# Rezoning Transportation Analysis

Petition Number: #2021-277

## Revision Log:

Date	Description
05-18-2022	First Review (WB)
09-21-2022	Second Review (AO)
10-26-2022	Third Review (IW)
08-21-2023	Trip Gen. Update (TP)
08-24-2023	Fourth Review (NK)

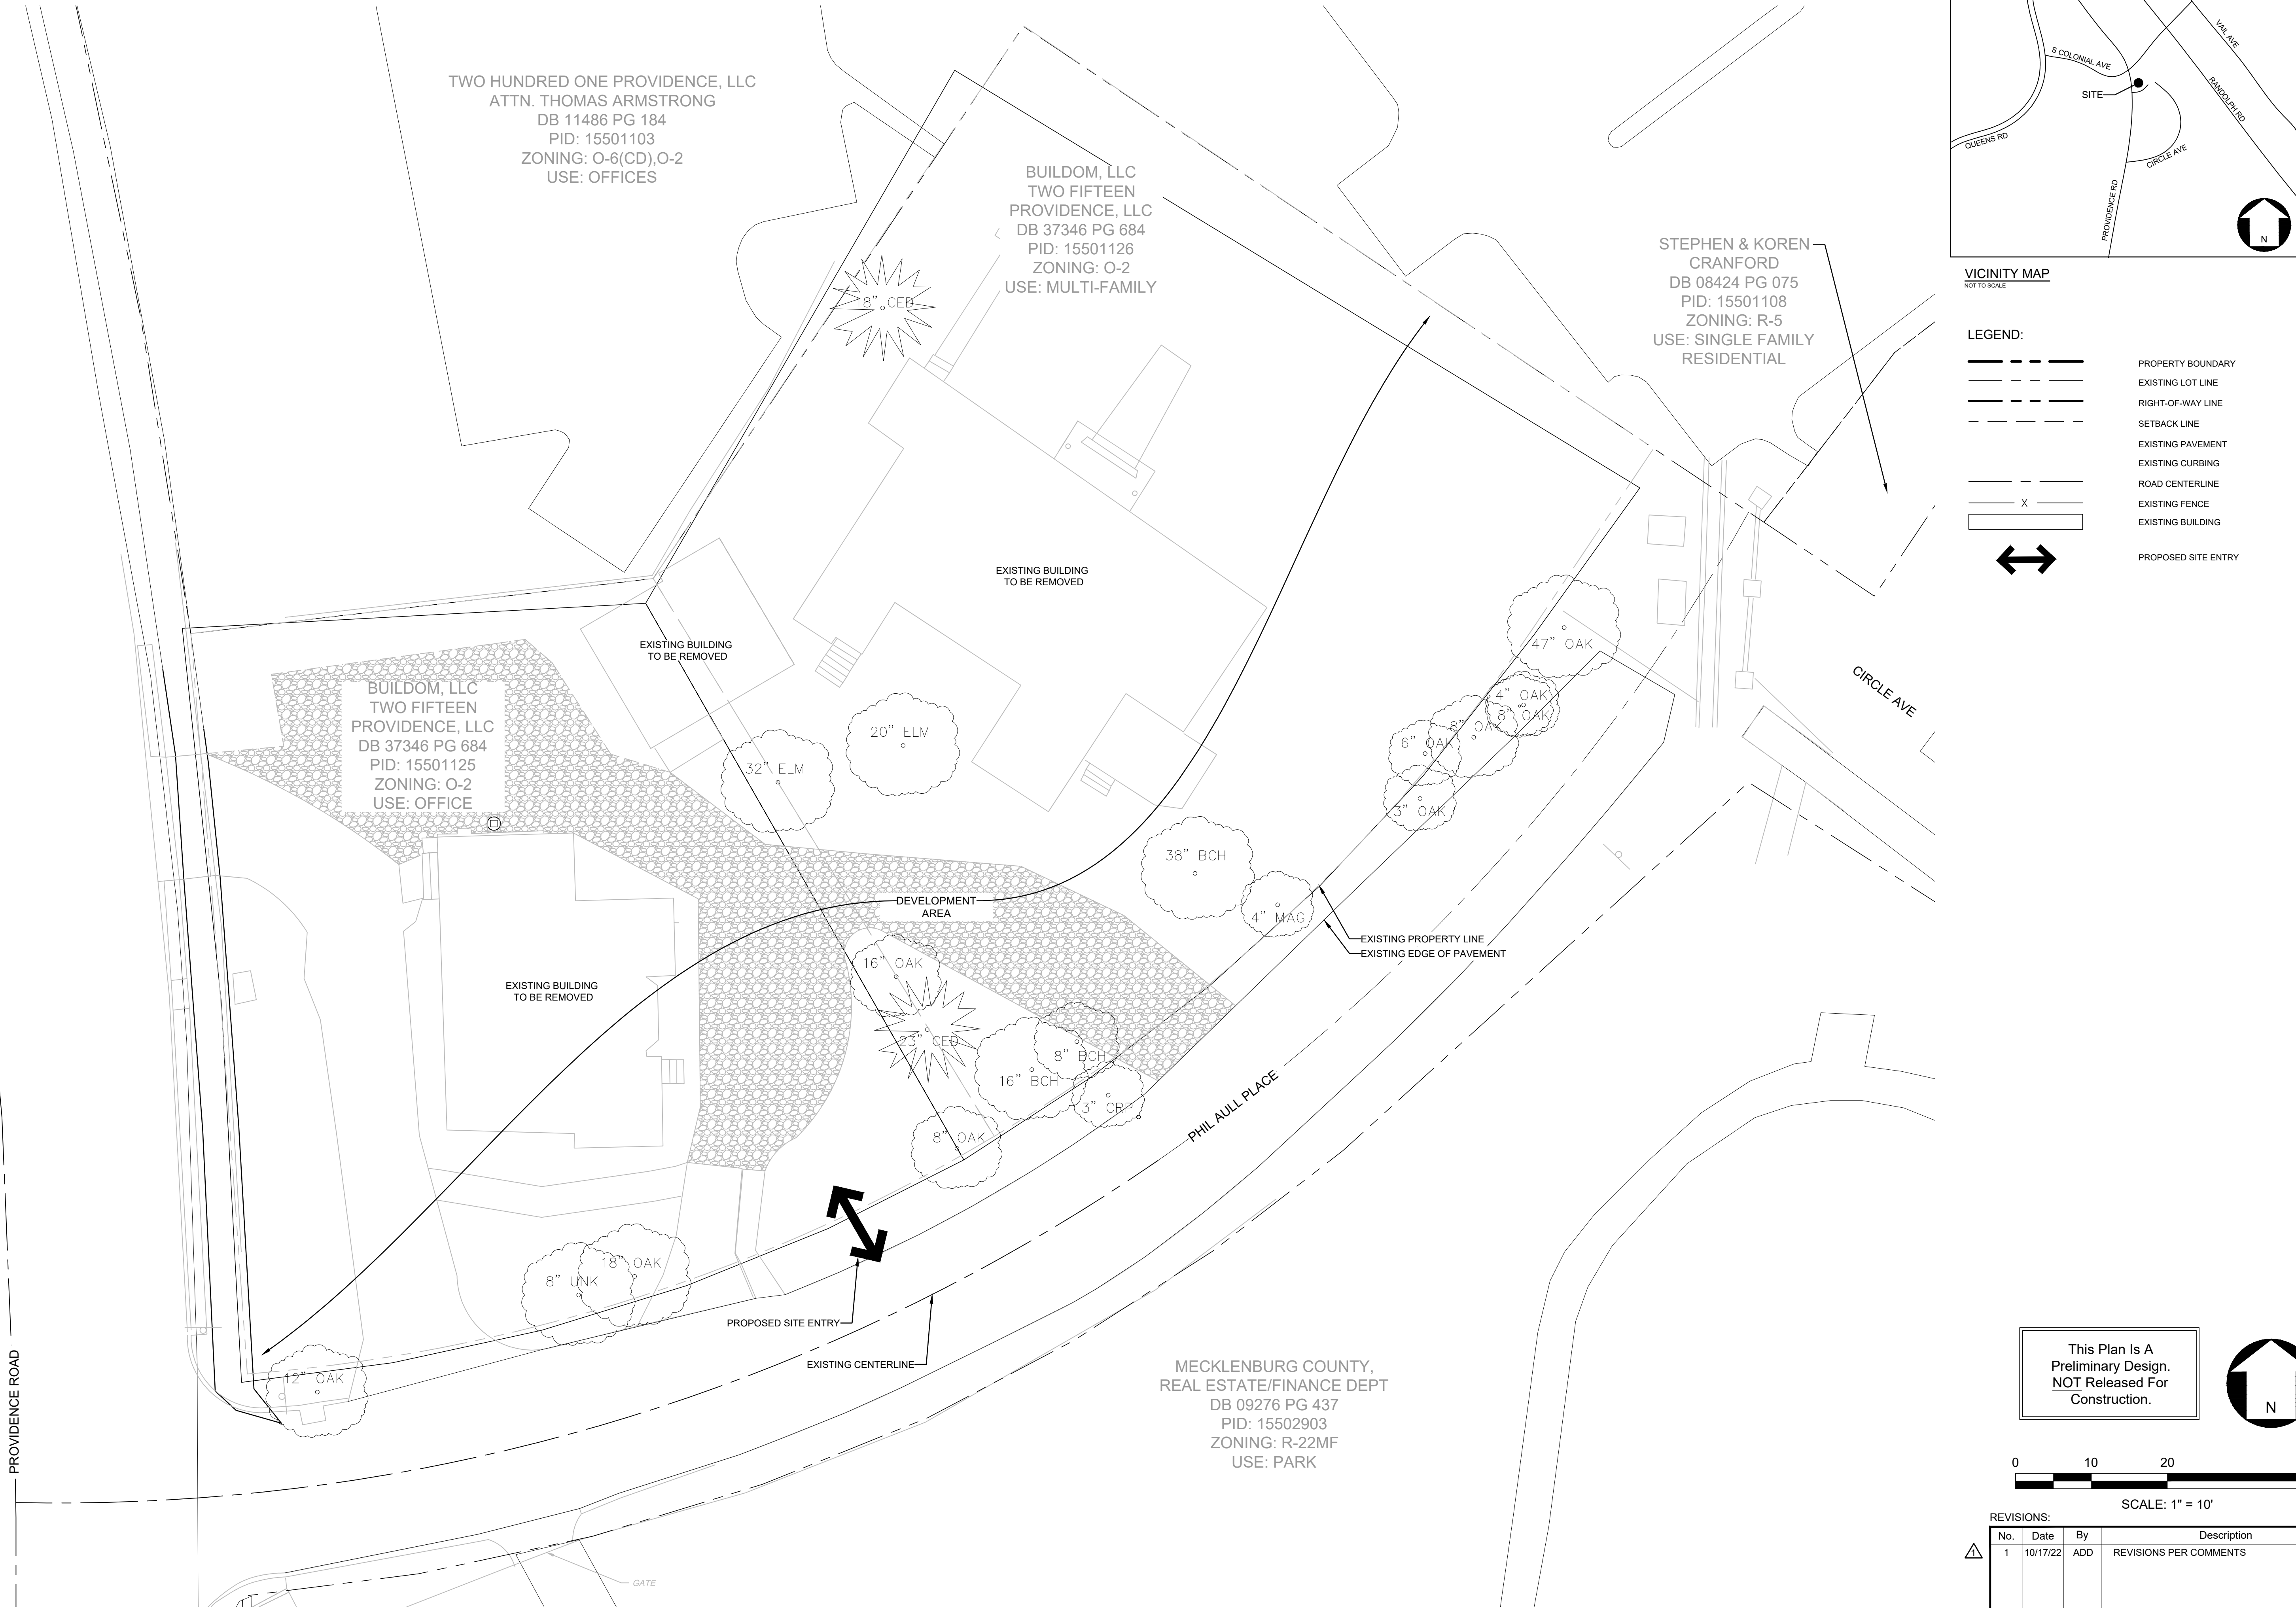
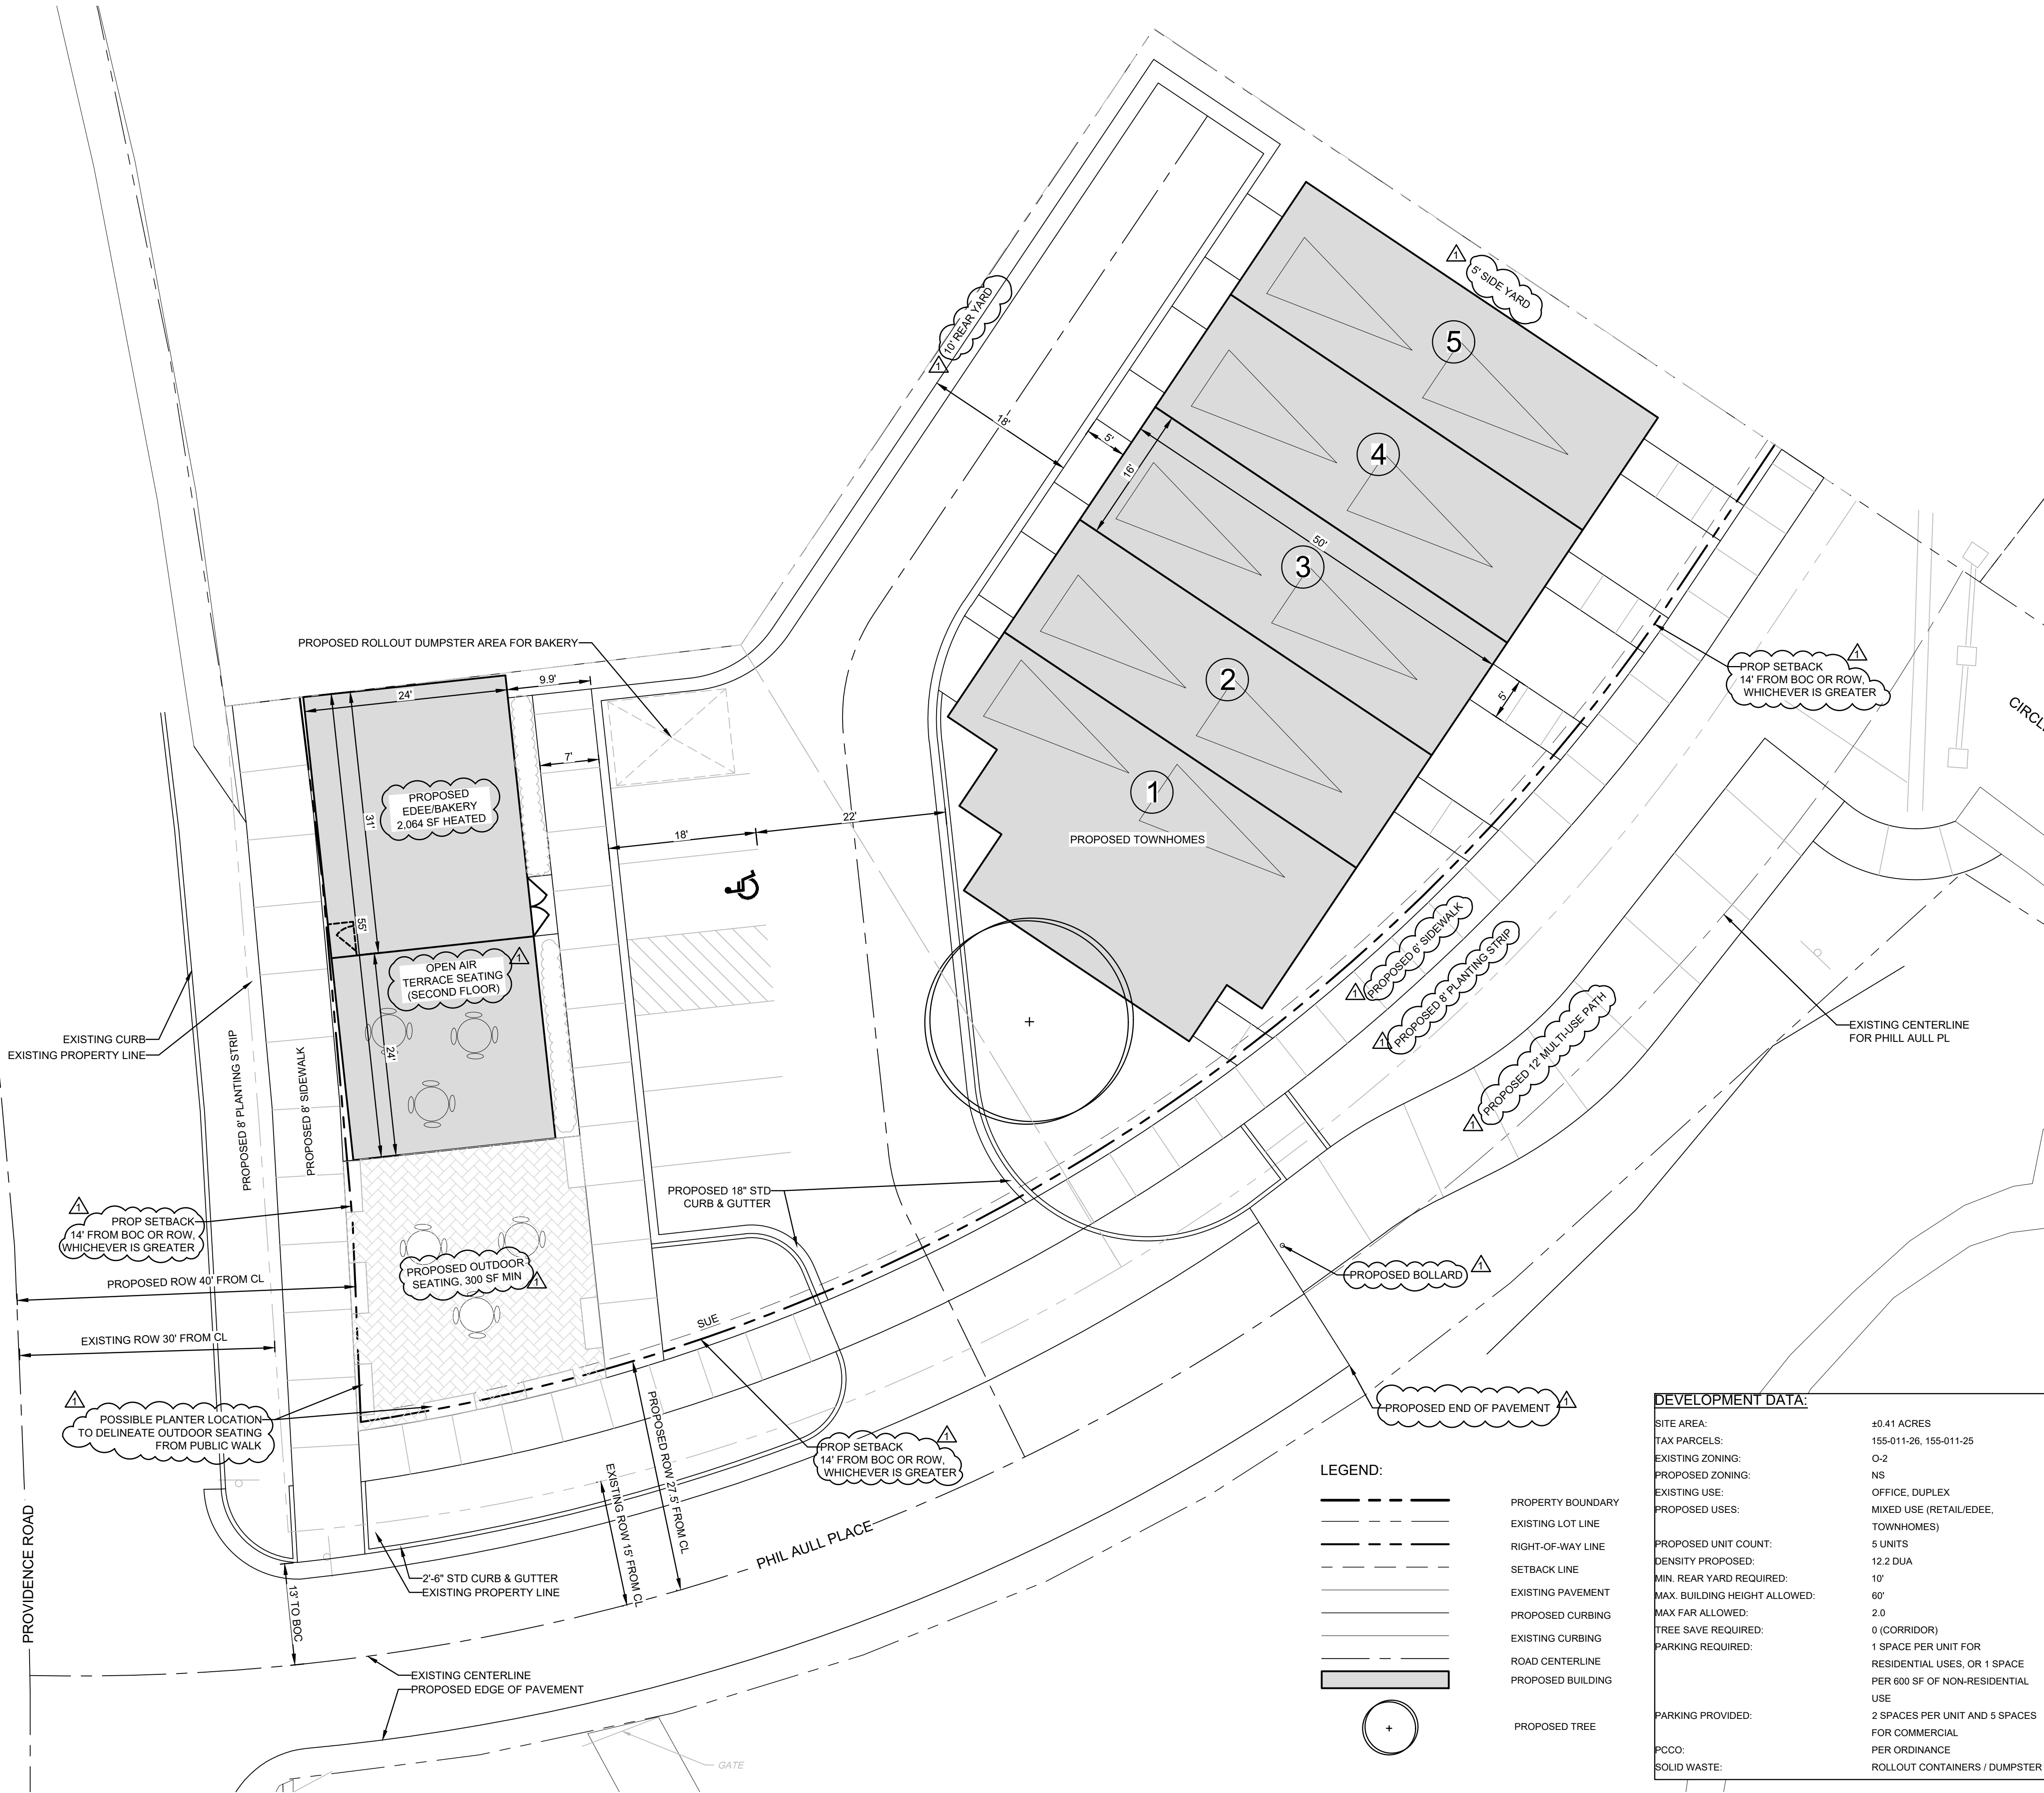
### 3. ~~Outstanding Comment from 5-18-22:~~ Revise site plan and conditional notes to commit to dedicate 40 ft (min) right-of-way from the Providence Road centerline. Provide a sidewalk utility easement (SUE) 2 ft behind the future back of sidewalk (50.5 ft from the centerline). The site plan shall label and dimension the right of way from the road centerline.

~~**Clarifying Comment from 10-26-2022:** Provide and show sidewalk utility easement (SUE) 2 ft behind the future back of sidewalk (50.5 ft from the centerline) on Providence Road.~~

6. ~~Outstanding Comment from 5-18-22:~~ Site plan and conditional notes revisions are needed to provide an ADA compliant pedestrian connection from Phill Aull Place to Circle Avenue.

~~Clarifying Comment 10-27-22:~~ Label and add conditional note committing to ADA compliant connection.
